Department of Transportation

September 10, 2021

RE: HCD Properties |Minor Sub MS218

Figure 2  
Site Plan

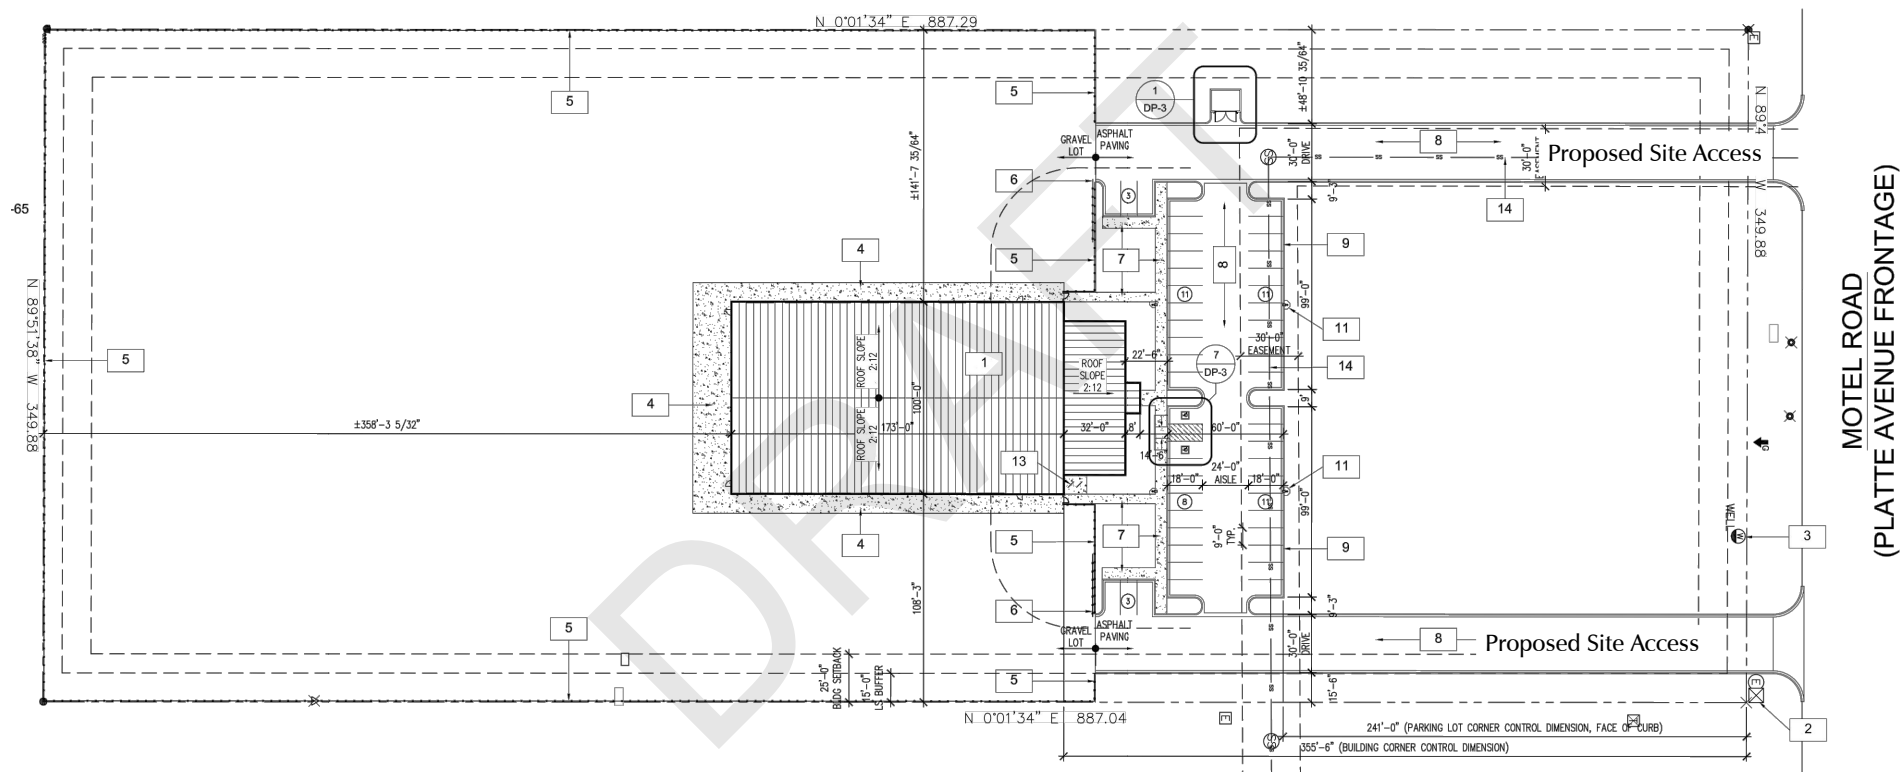
- Traffic Study (LSC#S214660) states that only one access is proposed for the property; however, the site plan depicts two. The property shall be limited to one single point of access at the eastern most proposed access intersection.
